CASTLE GROUP

SSD-9472 Sikh Grammar School
Lots 42 & 43 DP30186 151-161 Tallawong Road Rouse Hill

The following forms our submission regarding the above Development Application for a proposed school. We are making a submission on behalf of 95 Tallawong Road Rouse Hill (REK Developments No3 Pty Ltd ATF REK Developments No3 Unit Trust).

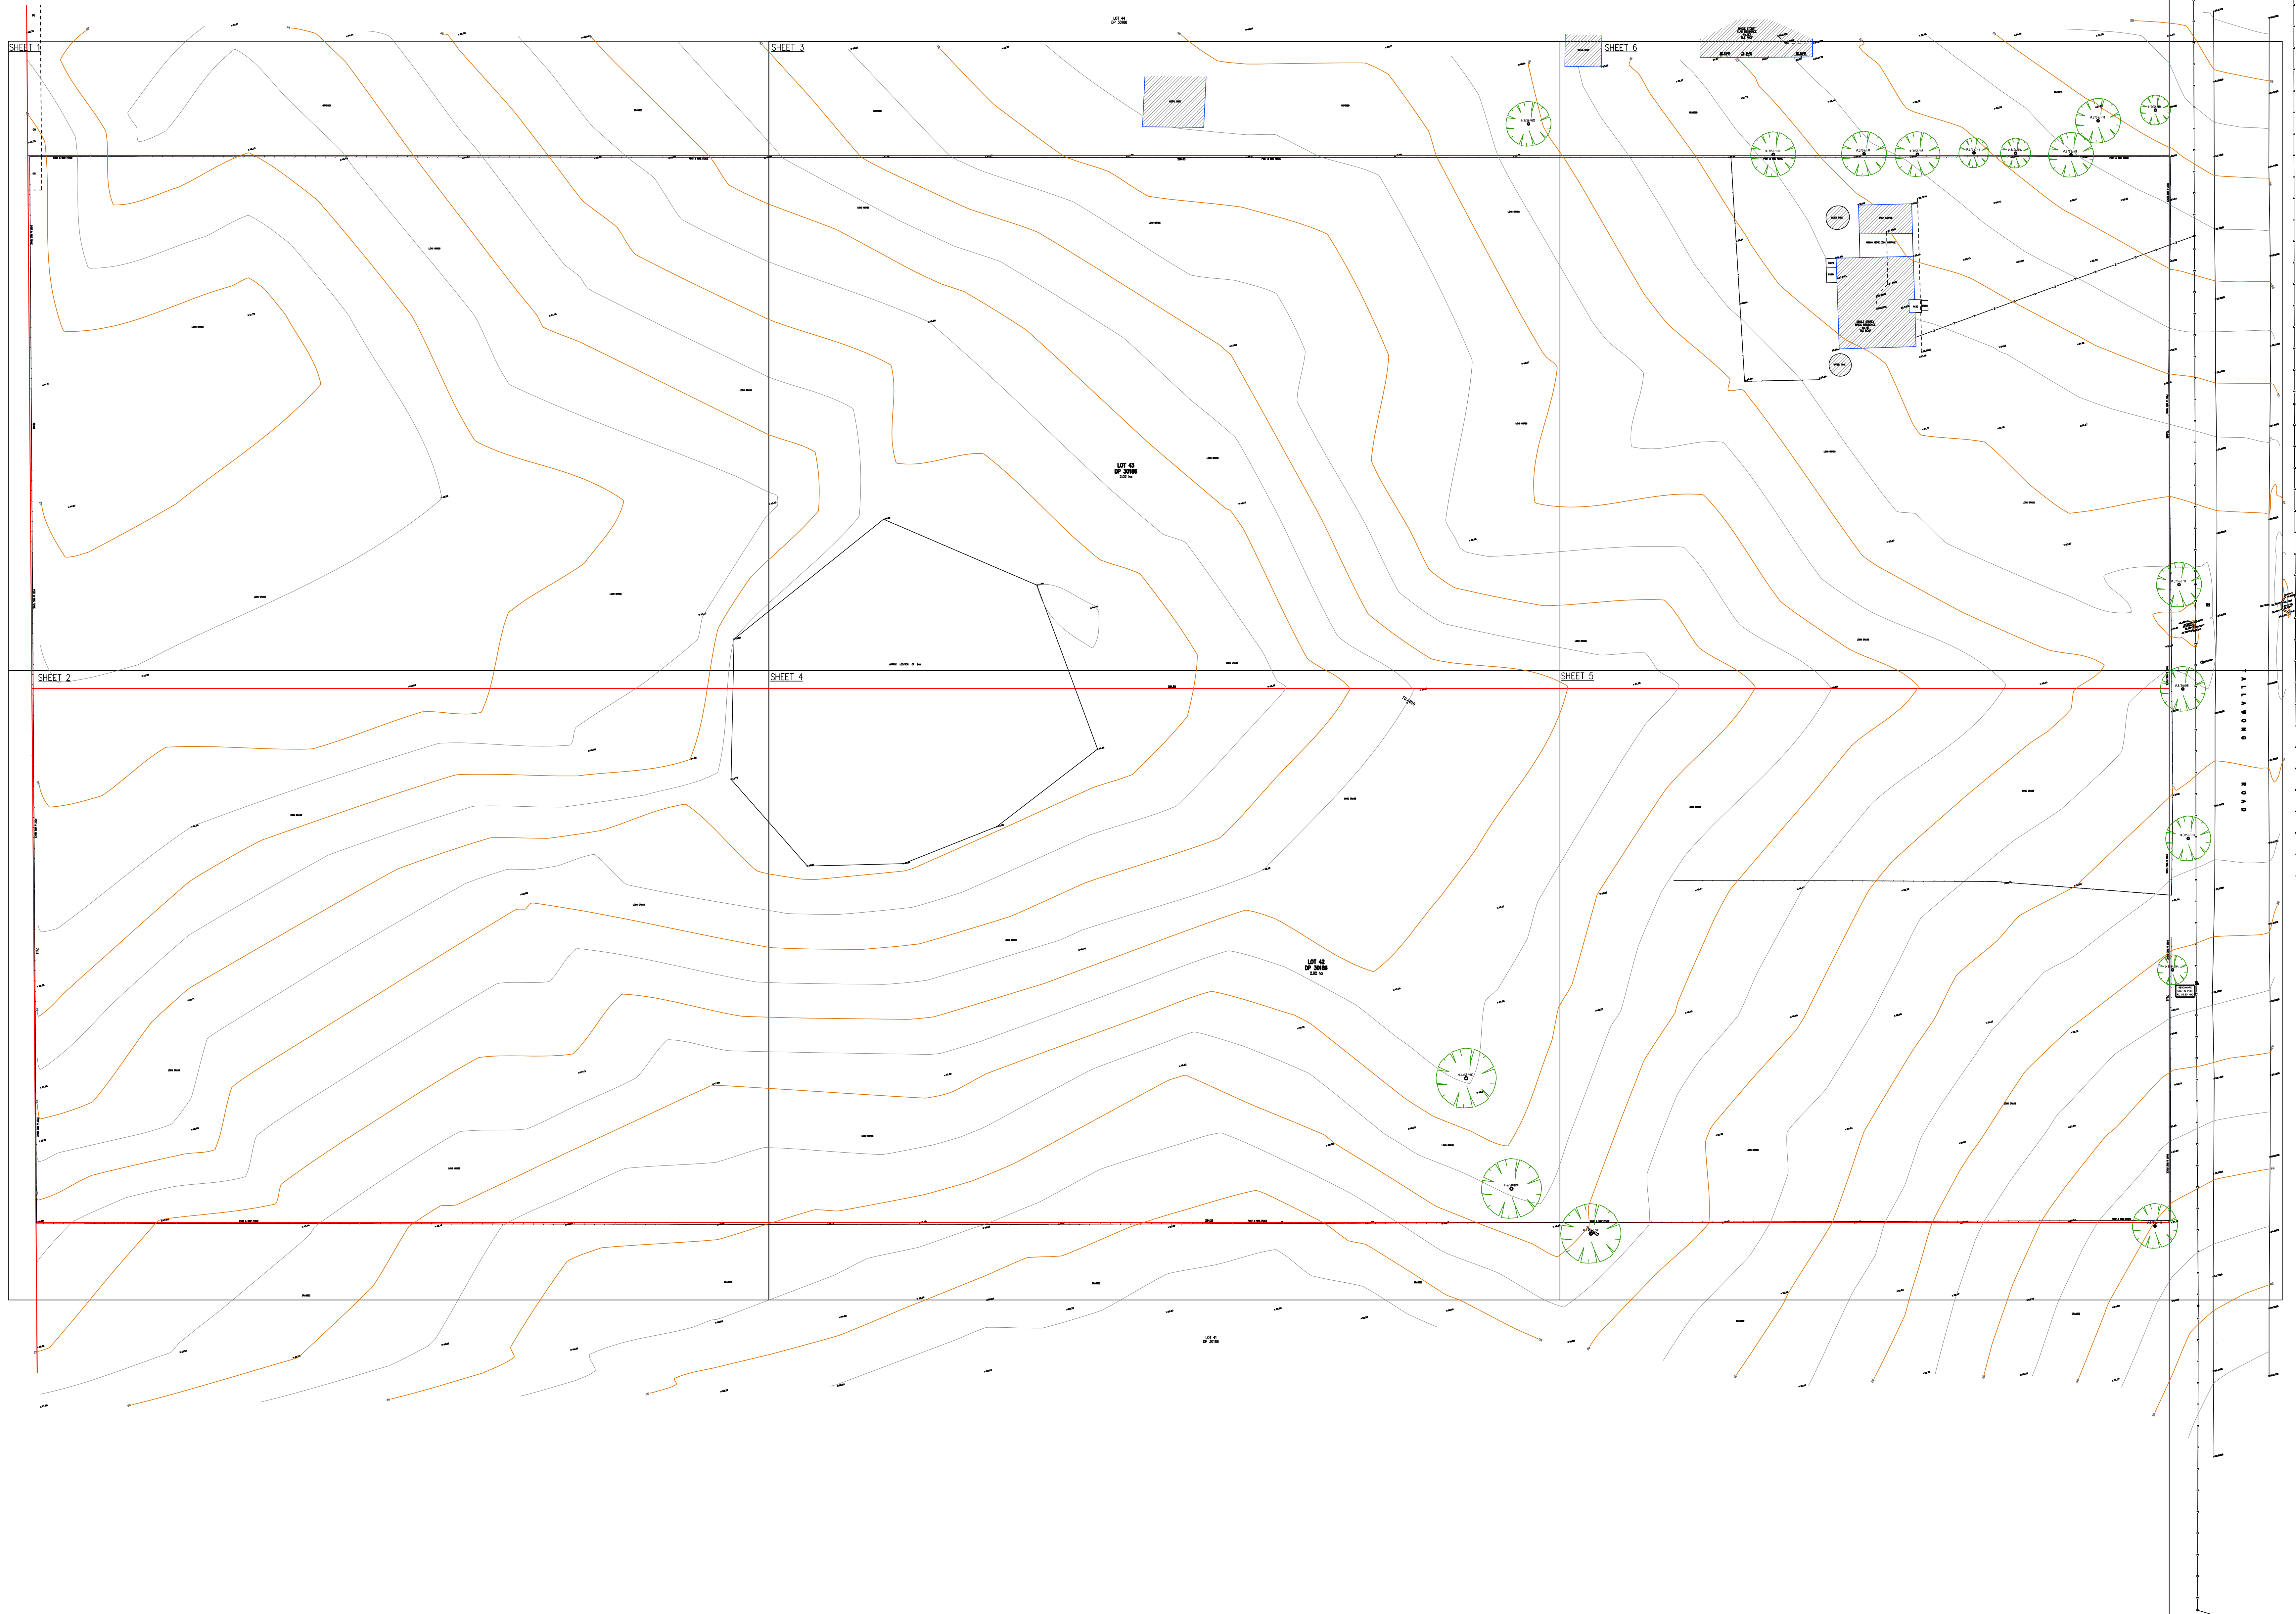
- The survey plan is illegible as only Sheet 1 has been included whereas Sheets 2-7 which have not been included presumably provide a greater scale and legible text.
- The architectural plans do not provide any measurements from natural ground level making precise measurement of the building height and impact on the adjoining properties difficult.
- There are significant inconsistencies between the masterplan and the architectural plans. Building locations are substantially changed, land uses have been relocated and parking areas, bus layby and access arrangements are different.

Site Plan- Level -1 (Basement) DA101

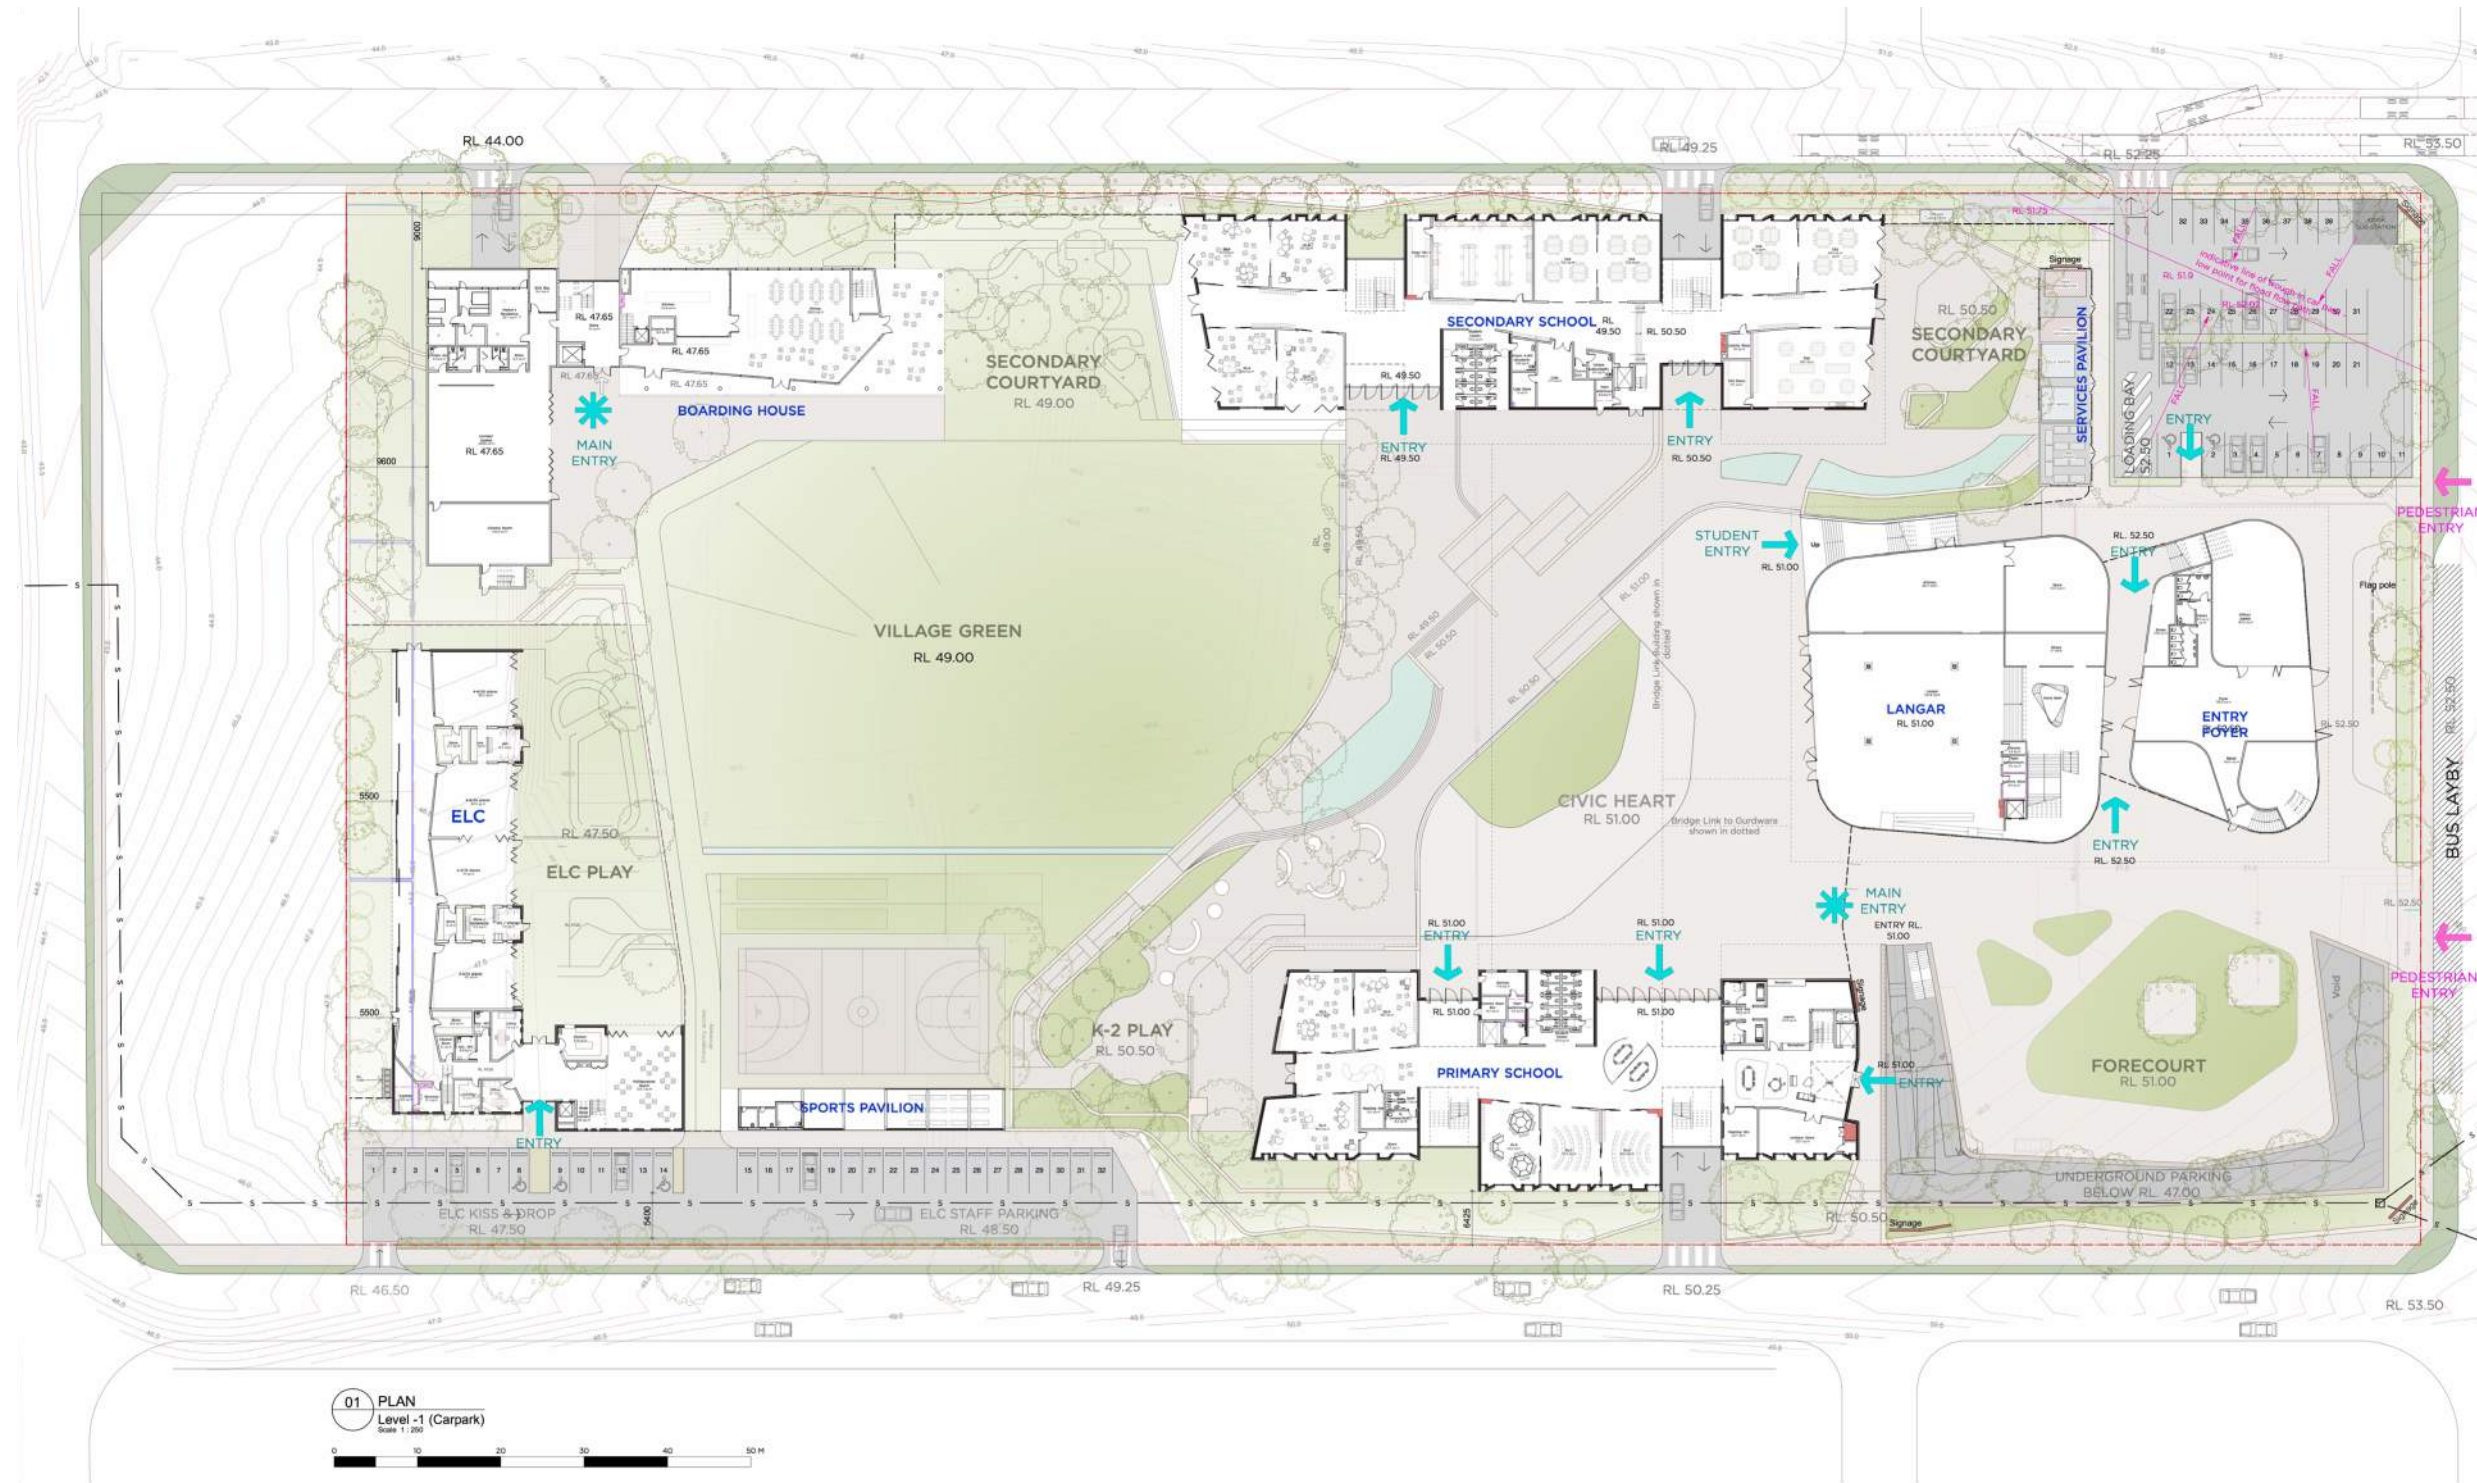
Vehicle access to the proposed basement is proposed to be via the new northern and southern roads. Further, access to the above ground parking is proposed to be provided via the northern half road.

In the interim and until such time as the neighbouring sites have been developed this access arrangement is problematic as these half roads are unlikely to be able to safely accommodate the vehicles movements expected to service the development during peak times.

Additionally, the turning manoeuvres indicated on the architectural plans cannot be accommodated without driving into our property, and no consent has been given to temporary or permanent works within our site.
